Modification of Project Approval

Project Approval:	MP 06_0025 granted by the Minister for Planning on 7 January 2009.
For the following:	Construction of the Vincentia District Town Centre
Approval Authority:	Minister for Planning
The Land:	Lot 802 DP 1022286, Lot 73 DP 874040
Modification:	MP 06_0025 MOD 7: the modification includes: <ul style="list-style-type: none">• revisions to plantings along the Moona Creek Road frontage• revisions to plantings to part of the overland flow corridor• details of a recycled timber screen along the frontages adjacent to the loading area• incorporation of a substation and sprinkler tank into Stage 1A.

2.52. Extent of Modification 7 Landscape Works

2.53. Additional Screen Planting

Figure 7 | Proposed landscape plan showing detailed plantings (source: Mod 7 application documents)

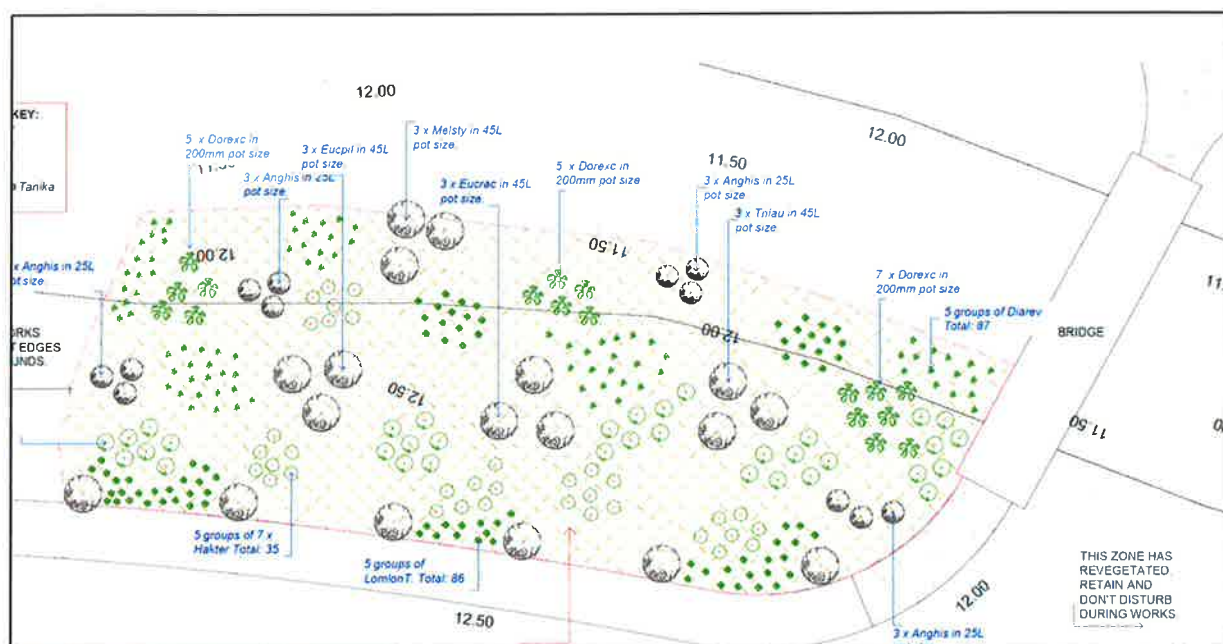
The landscaping plans approved as part of Modification 7 only apply to the areas designated on the plans as being within the 'proposed extent of works'. All other parts of the site are to be landscaped in accordance with the landscape plans prepared by Scott Carver and approved as part of Modification 6.

Prior to the issue of a Construction Certificate for the works subject of MOD 7, additional screen planting with a mature height of 1.5m shall be planted in front of the full length of the open palisade style fencing shown as an 'existing fence' adjacent to the loading and services area to the satisfaction of the PCA.
